# SCOPING OPINION

## Proposed Hydrodec Oil Re-Refinery

August 2015

This is the Scoping Opinion (the Opinion) provided by the Secretary of State in respect of the content of the Environmental Statement for Hydrodec Oil Re-Refinery, Eastham, Wirral.

Figure 3 Scale
 1:25,000@A3

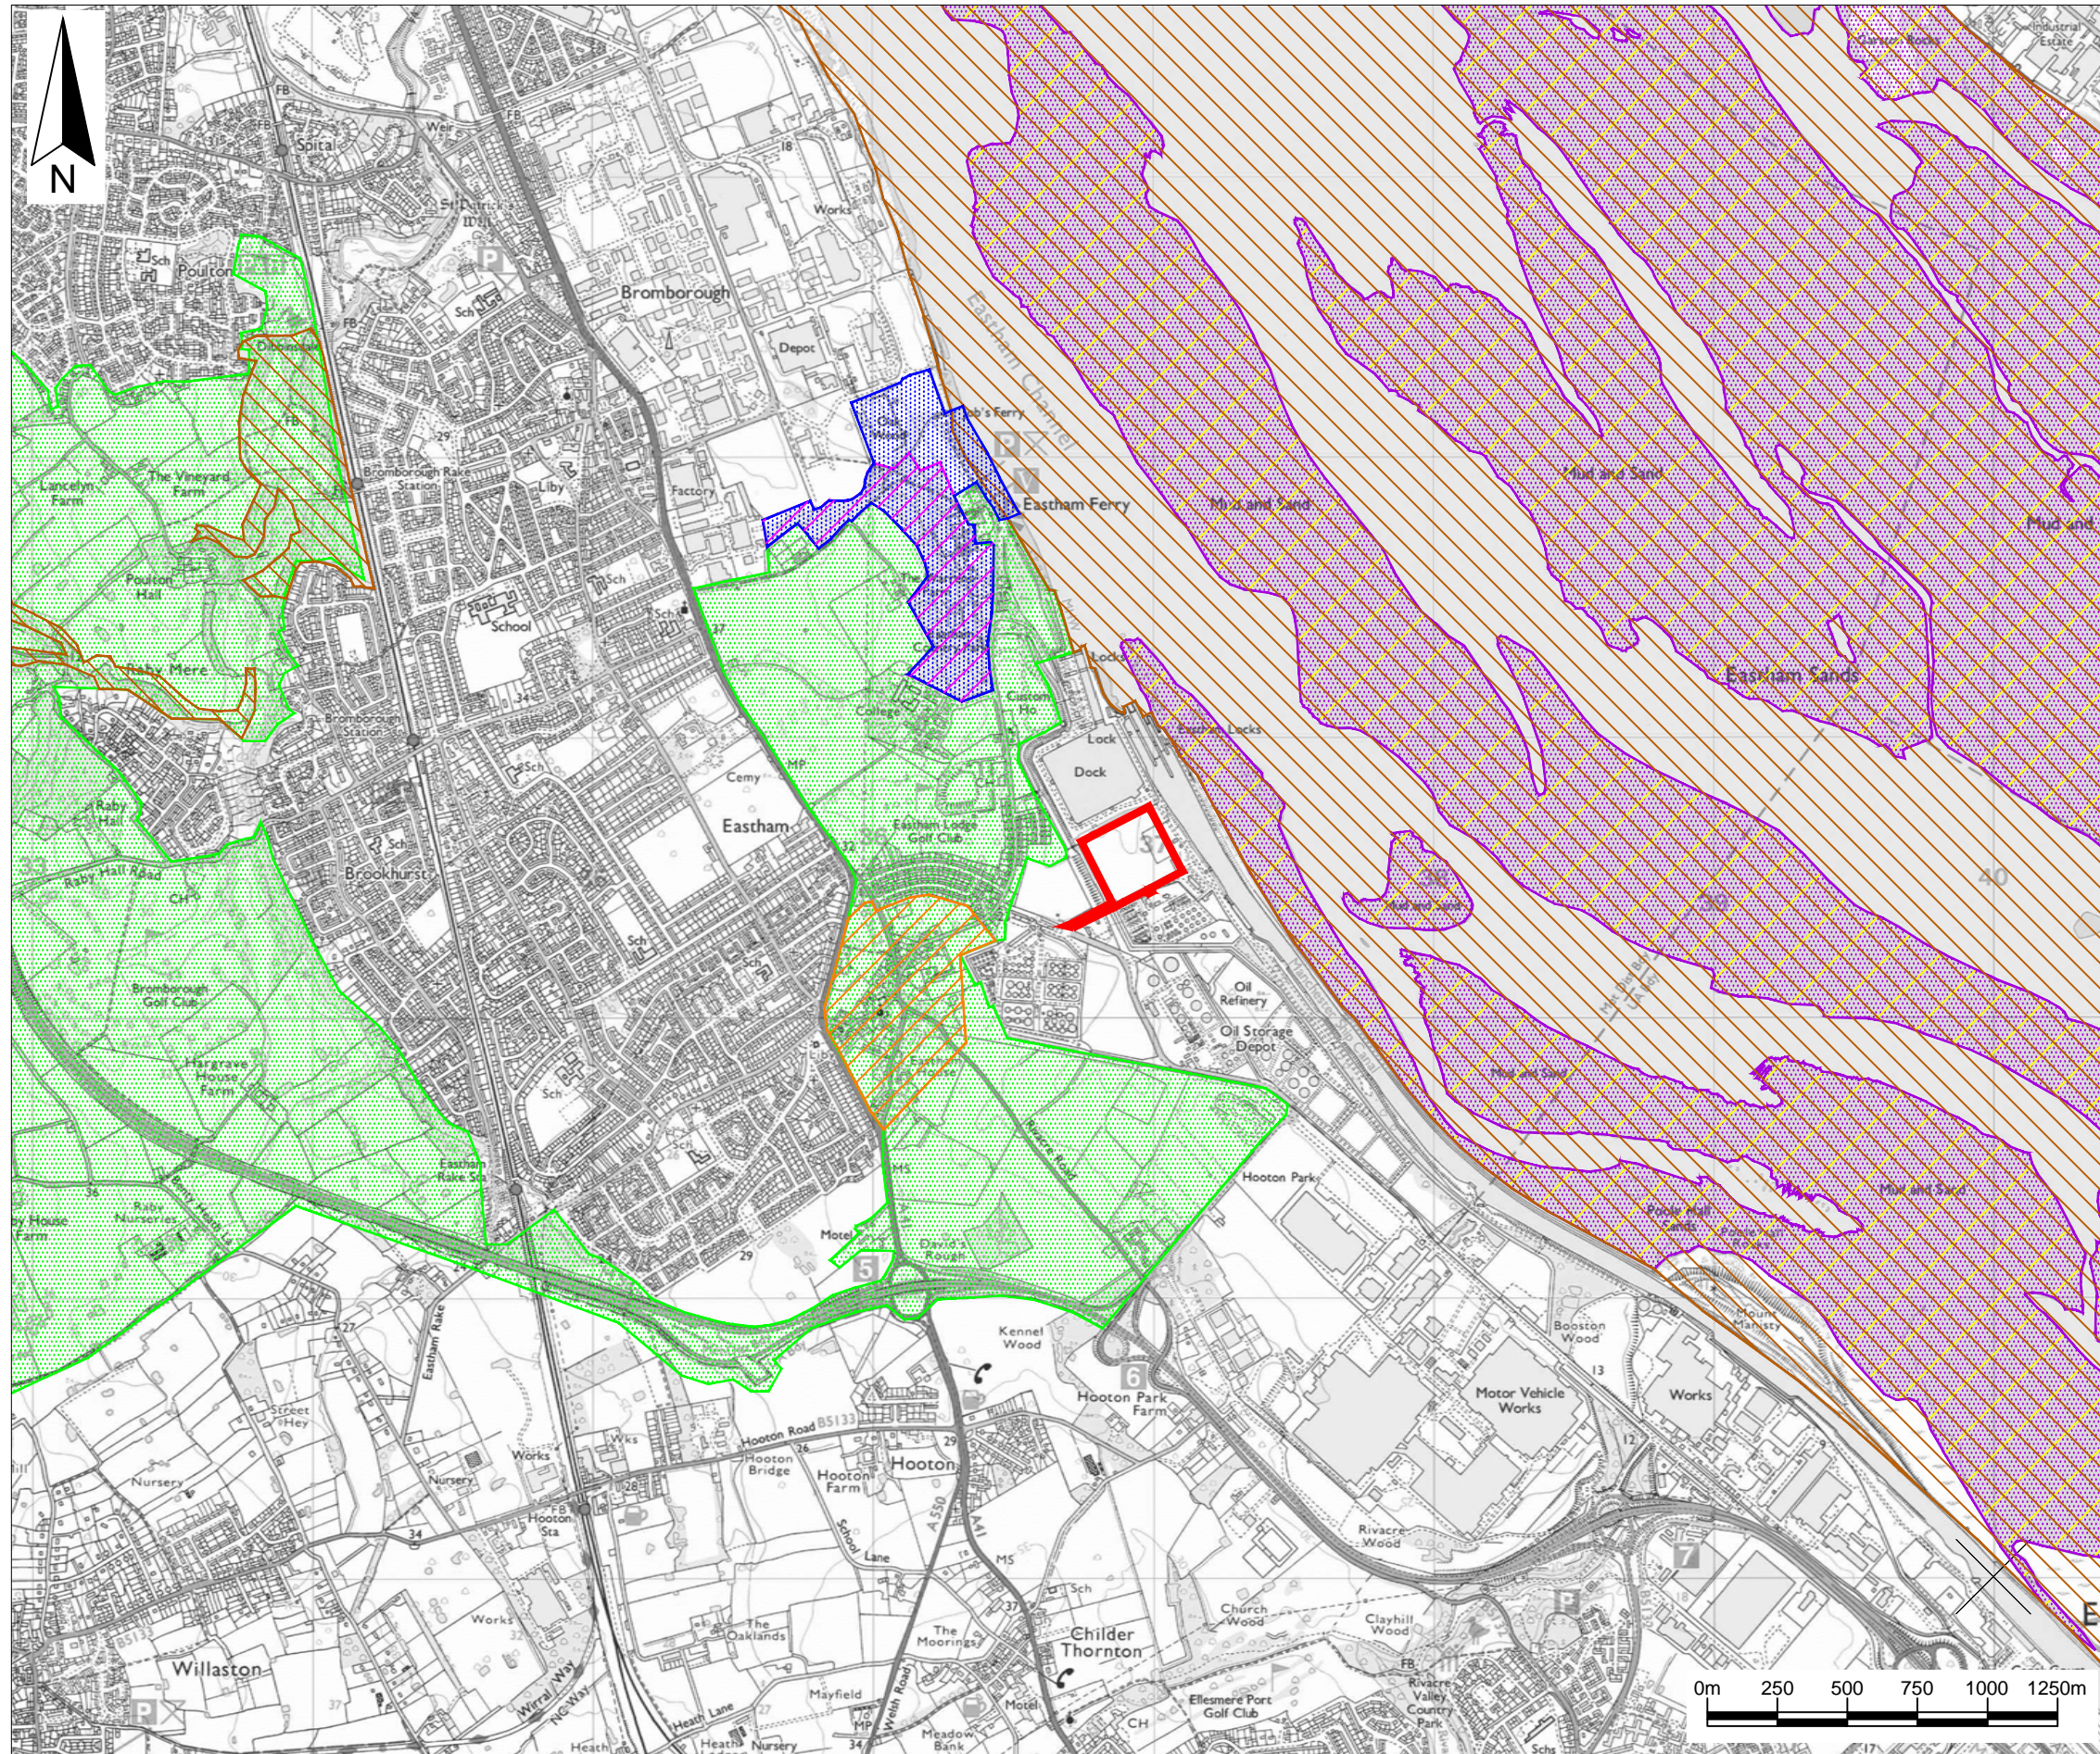
- 2.42 The Secretary of State is unclear why the key to Figure 3 of the Scoping Report notates the Key/Notes using the term 'approximate' location. Every effort should be made to ensure that the ES depicts the environmental baseline as accurately as possible.

Figure 4 Scale: Not to scale

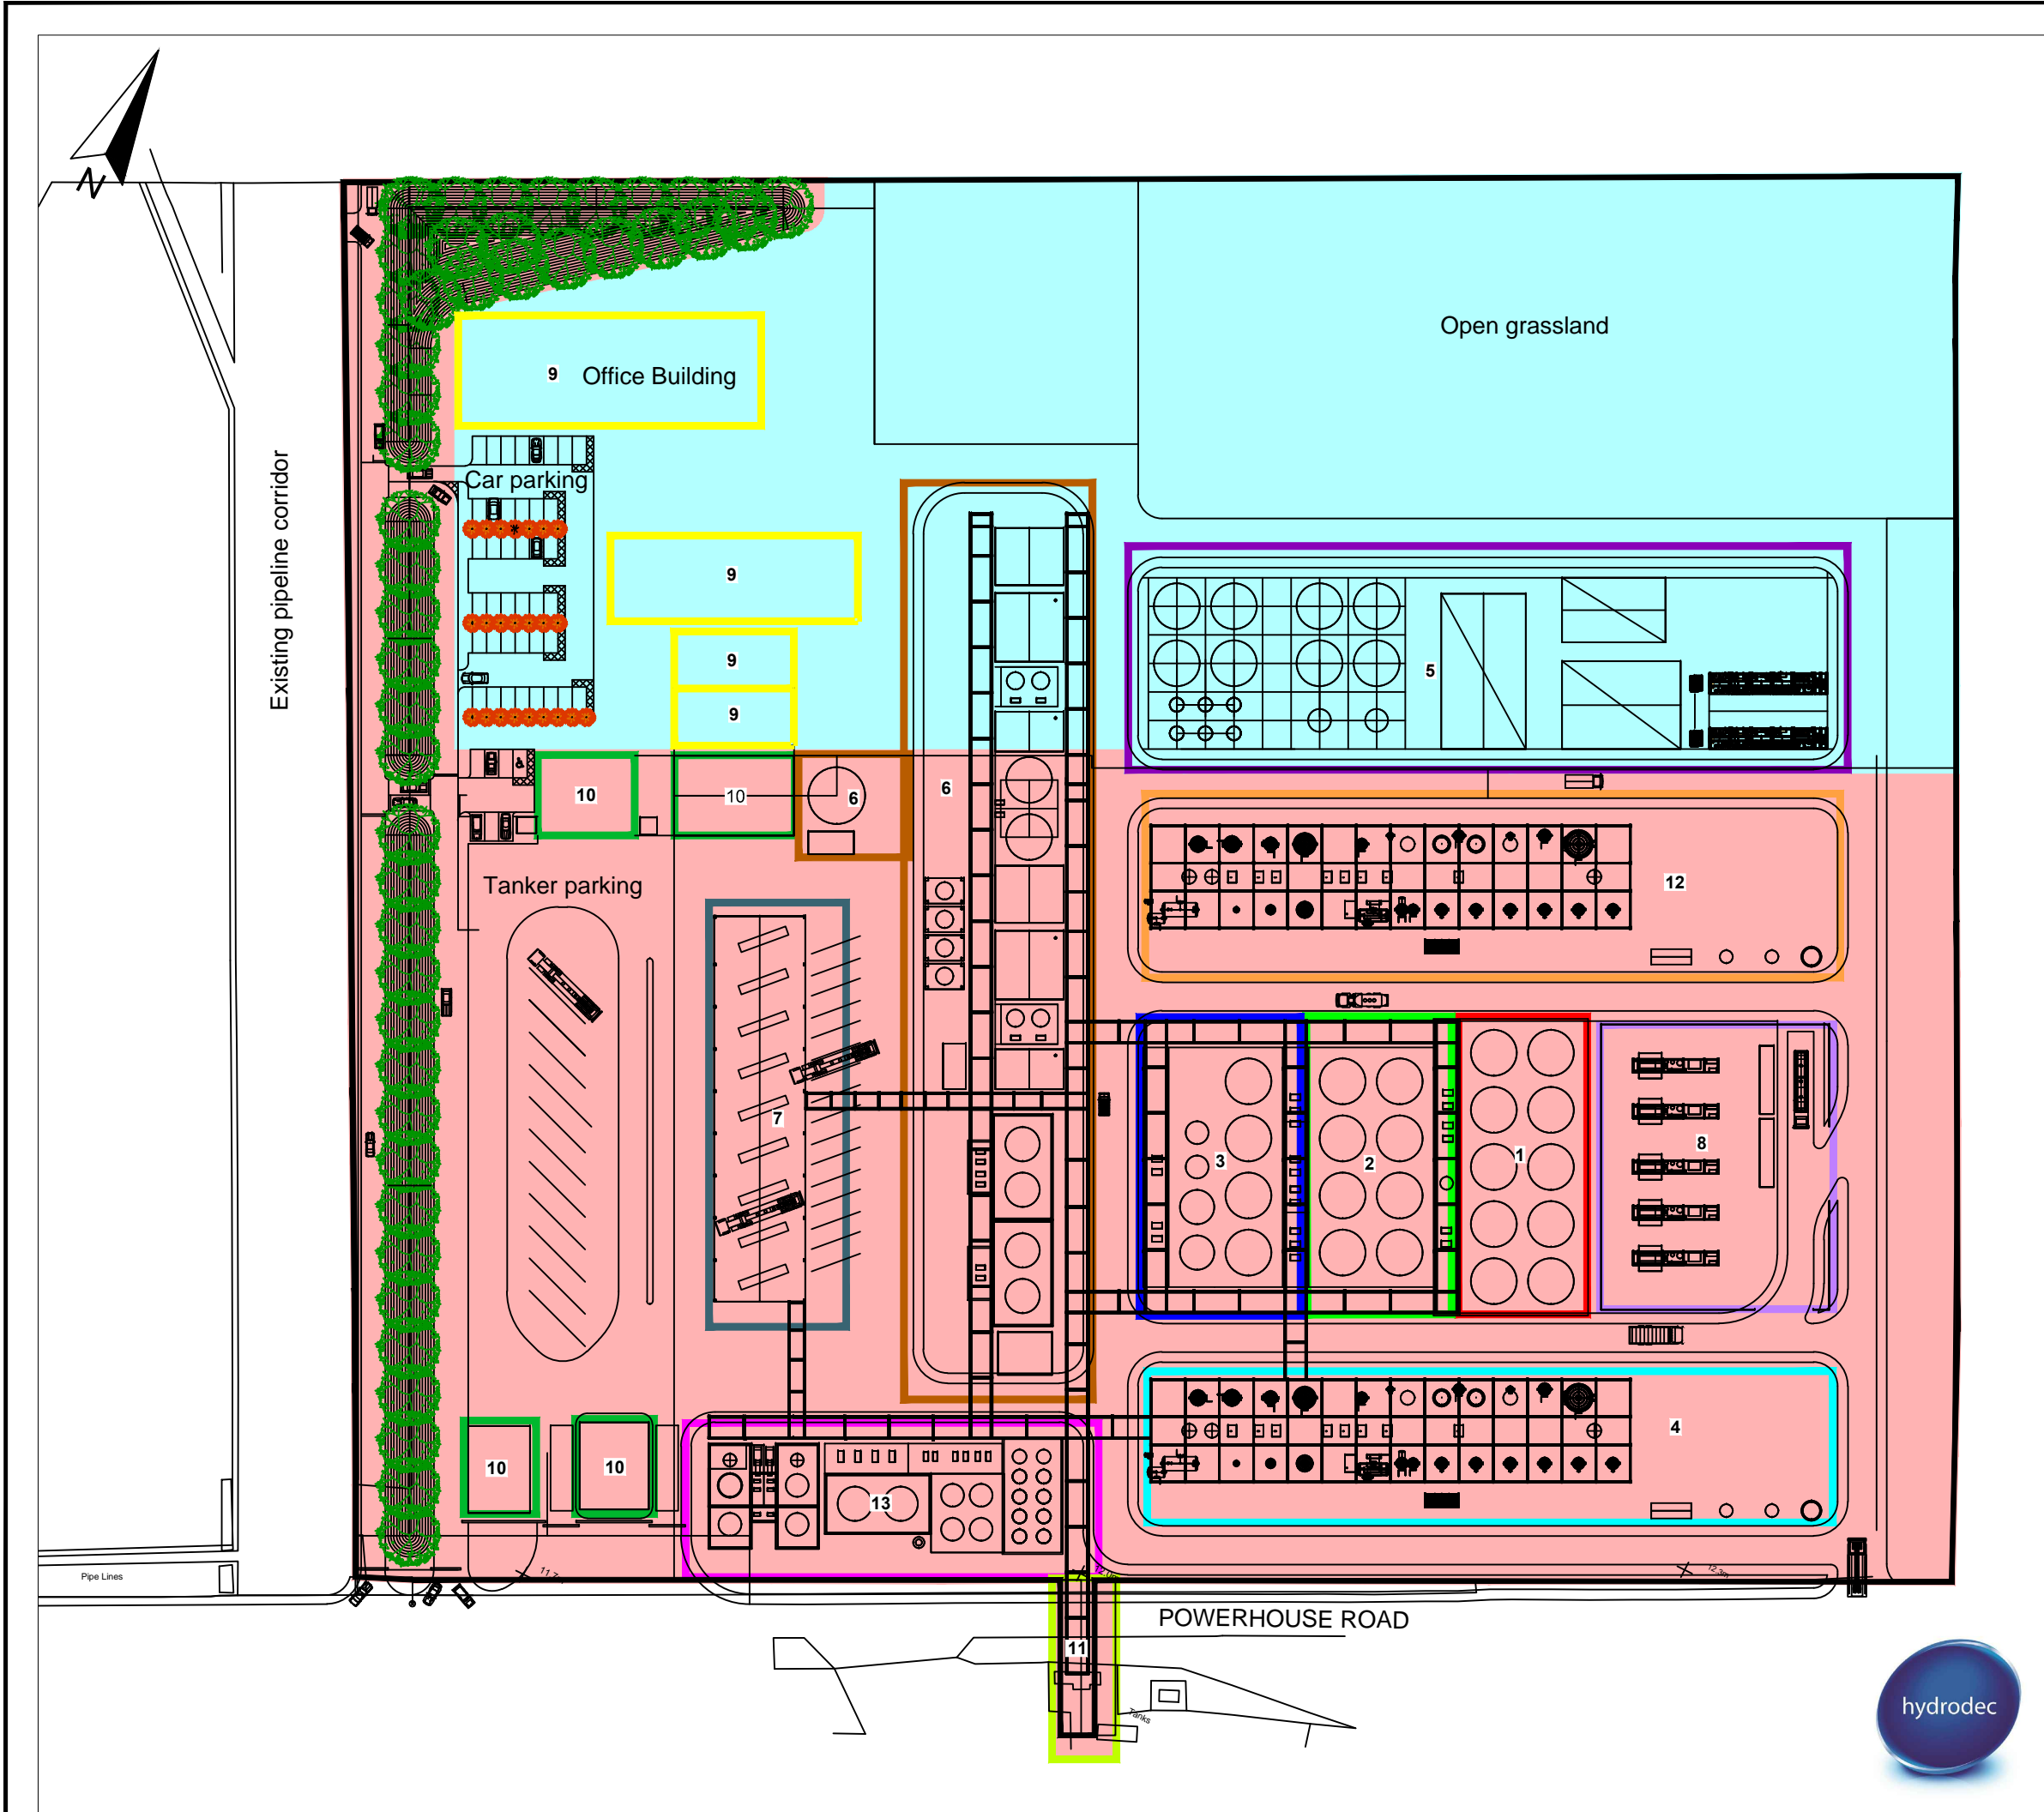
- 2.45 Given the number of different elements within the proposed development, it would be useful if the numbering of the project elements within the figures was also used within the text describing the project. This would aid in the understanding of the project for the reader and enable quick cross-referencing. The ES should also use consistent terminology between the text and the figures; for example paragraph 3.11 of the Scoping Report refers to a sub-station at what the Secretary of State assumes to be number 10 on Figures 4 and 5; however these figures do not use the terminology 'sub-station' and instead refer to a 'transformer building'. It is unclear whether or not this is the same structure.

- 2.46 The text of the ES should clearly differentiate between the project elements that would be constructed in Phase 1 and Phase 2. In the Scoping Report, paragraphs 3.14-3.18 follow on from a description of Phase 2 elements, however these paragraphs identify a number of project elements which would appear to be necessary for the operation of either phase (and includes the pipe bridge to NuStar bridge which is shown on Figure 4 to be Phase 1); therefore it is unclear whether or not these are specific to Phase 2. Figure 4 also depicts the 'base oil plant 2' being located in the Phase 1 development area, whereas paragraph 3.12 describes the second base oil plant being part of development Phase 2. The applicant should ensure that the ES figures and text are consistent with one another.

- 2.47 The ES should specify how many units there would be within the base oil plants (numbers 4 and 12).
- 2.48 Figures 4 and 5 of the Scoping Report identify a dewatering tank farm (number 1) and service plant (number 6) which are not described within the text. The ES text should provide detail on this element.

- Emergency flare stacks at both base oil plants;
  - Fire water storage tank;
  - Pipeline corridors and pipe bridges; and
  - Site access points.
- 2.56 The ES should also provide an overview of the production process during the operational phase, including details of inputs and outputs of material types and quantities.
